Non Material Amendment – Demolition of existing structures and erection of 1 no. single-storey dwellinghouse.

Land North of Dagwood Farm, Ashfield Road, Elmswell, Bury St Edmunds, IP30 9HJ

Planning Reference: DC/23/01407

Drawing Title:
Proposed Elevations
Sheet 2

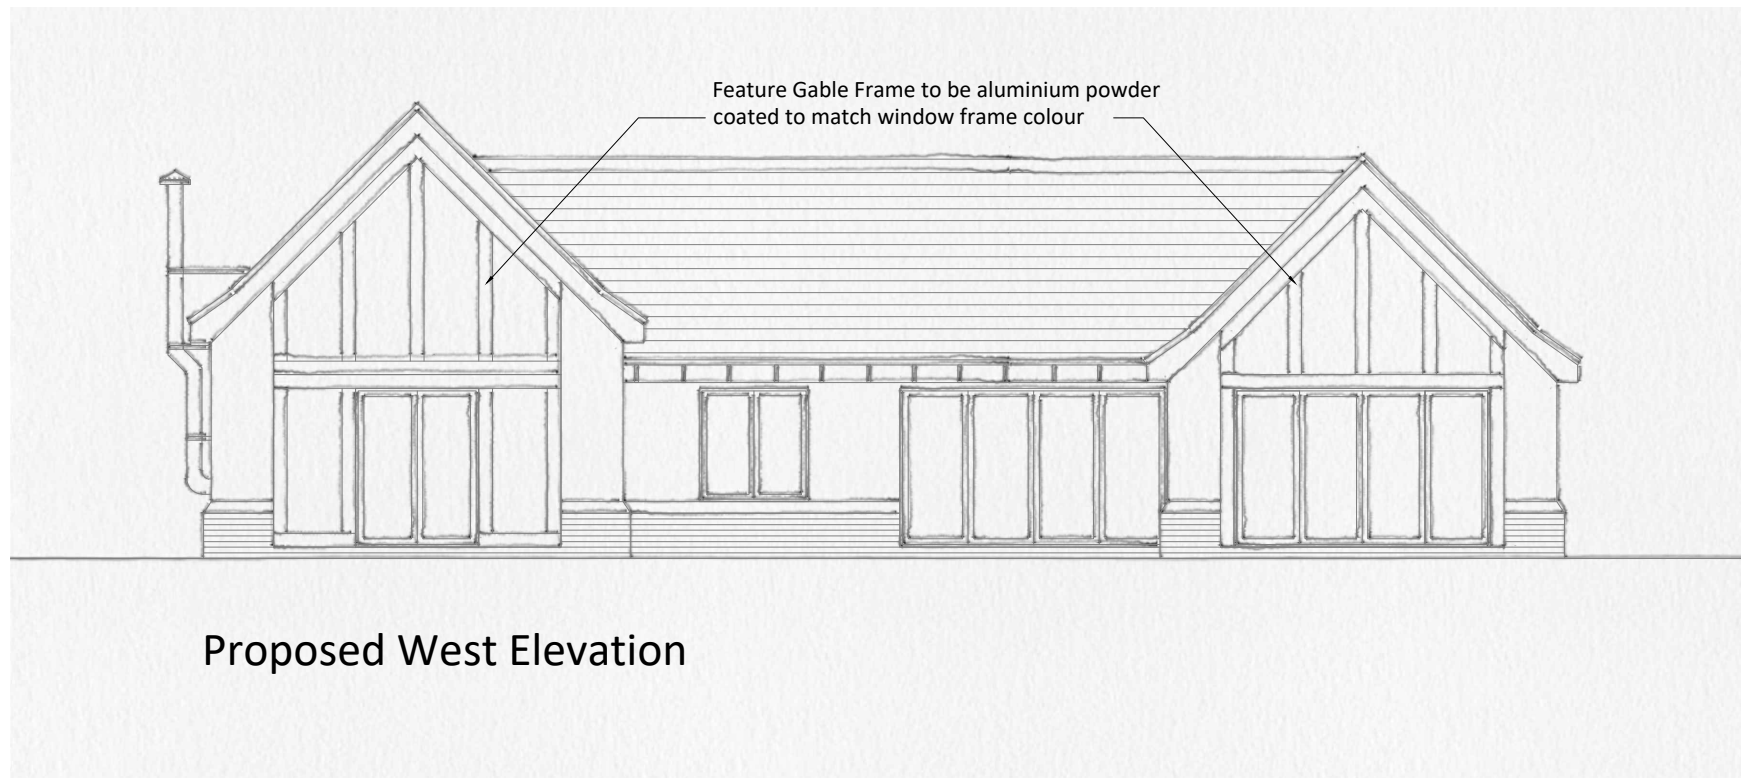
I write with details of the Non-Material Amendment application submitted today via the planning portal. Our client would like to add one rooflight to the first floor bedroom to improve natural light levels within the room. In addition, the gable frames to the west elevation will be finished in power coated aluminium to match the doors and glazing frames in these areas. All other gables will be in timber as approved. The proposed Non-Material includes the following:

- Revised drawings to show the new roof light and change to west elevations gable frames
- Revised Site Plan to show the addition of the rooflight in the roof plan.
